## Upper Heyford Village Group—observations in respect of the site listed below

### HEYFORD PARK CAMP ROAD UPPER HEYFORD BICESTER OX25 5HD Application No. 16/02446/F

HEYFORD PARK - PHASE 9, PUBLIC OPEN SPACE PLAN

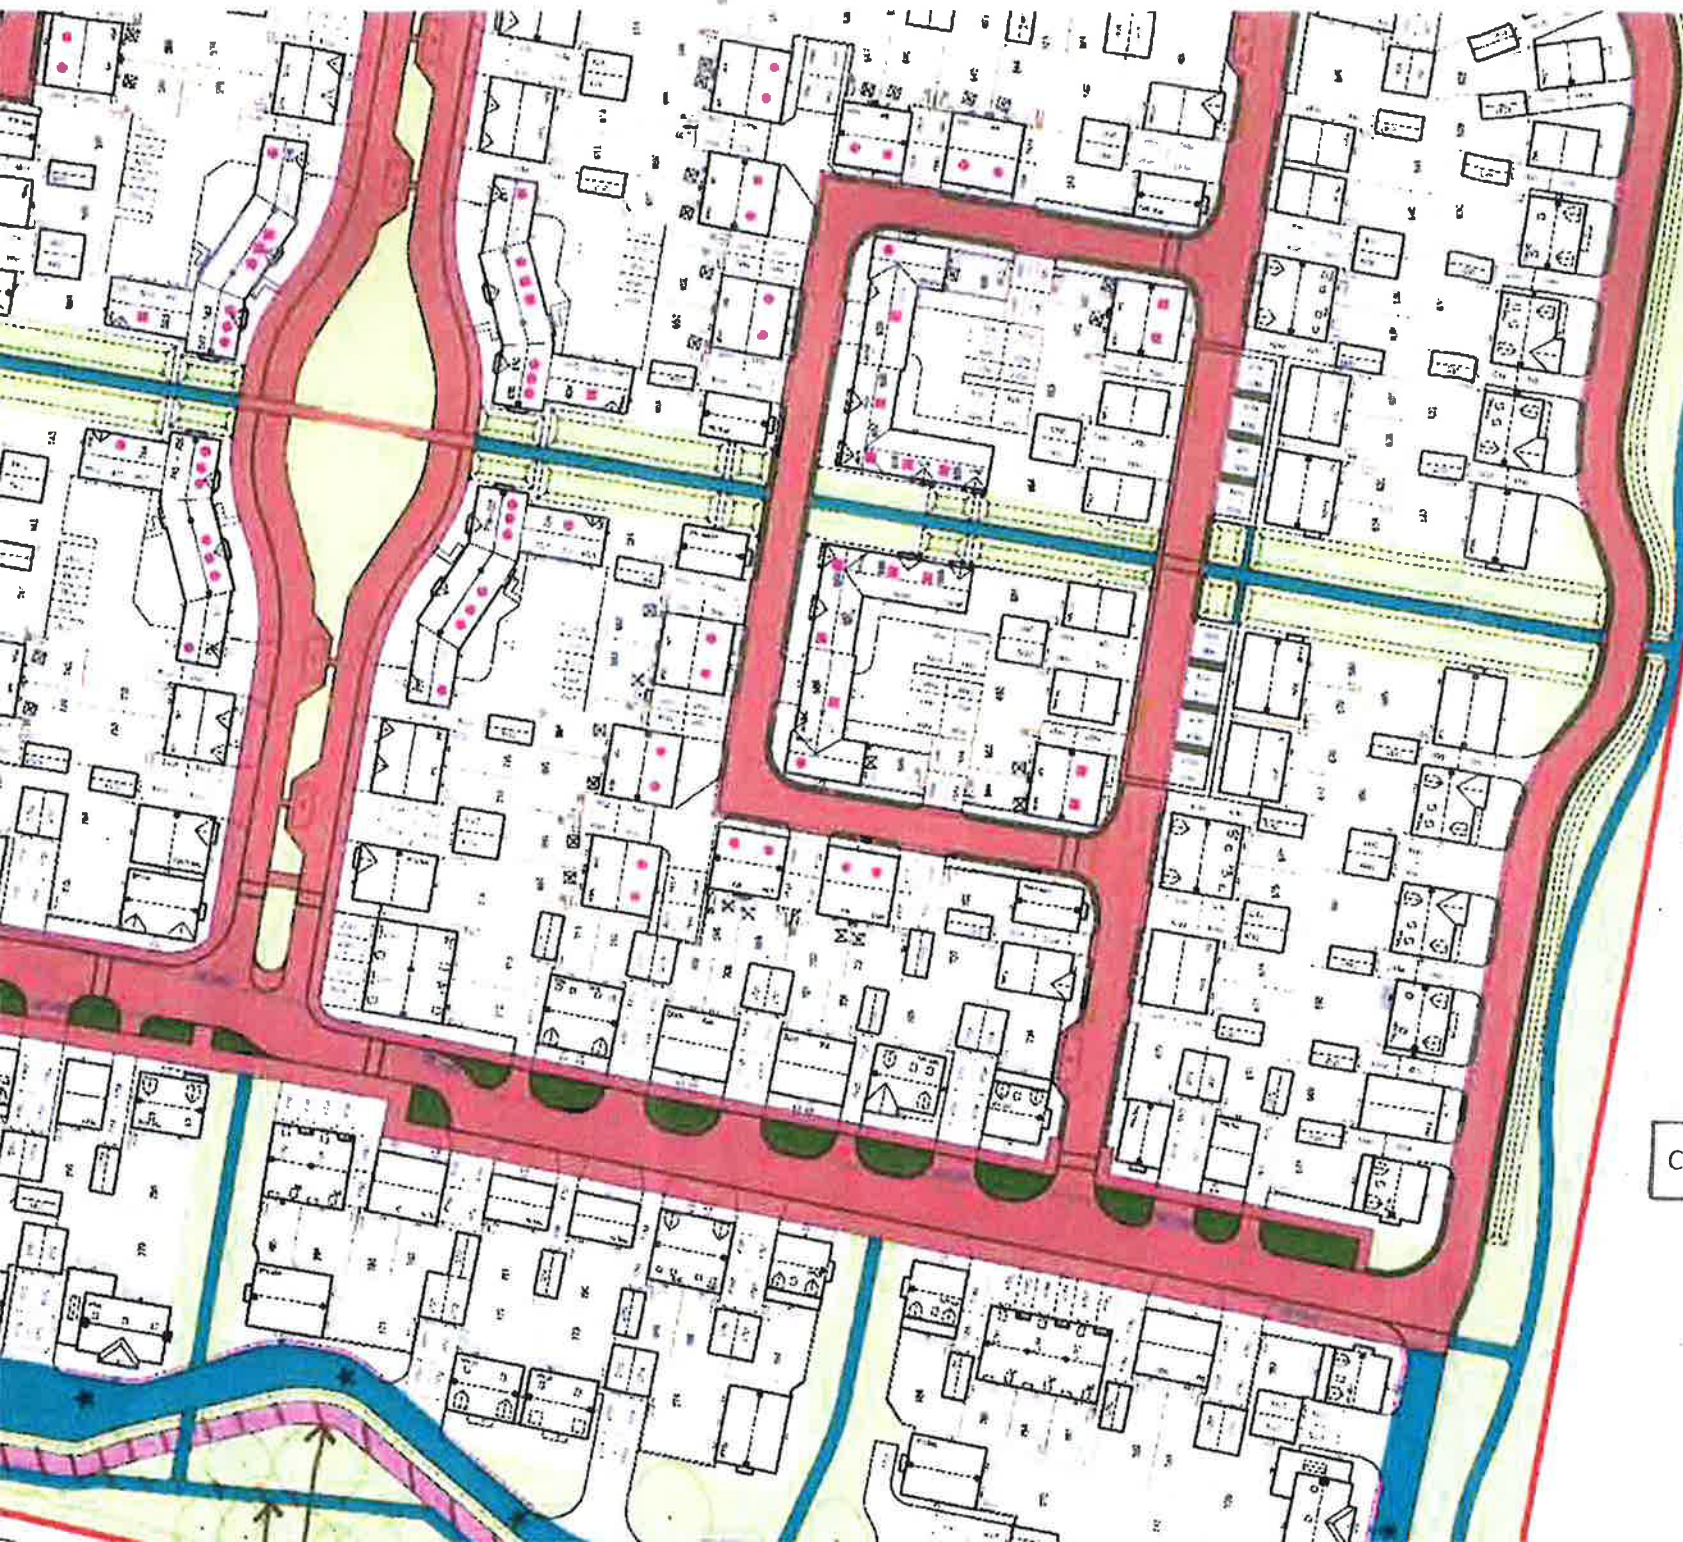
2. We are grateful that there is no proposal to have access roads onto the Kirtlington Road, however, we are dismayed at the very modest amenity area at the western edge of the development plan. A much wider area is needed to soften the impact of the new housing as the landscape changes to open countryside beyond the hedge on the west side, as requested by parishioners and shown on documents previously submitted to CDC.
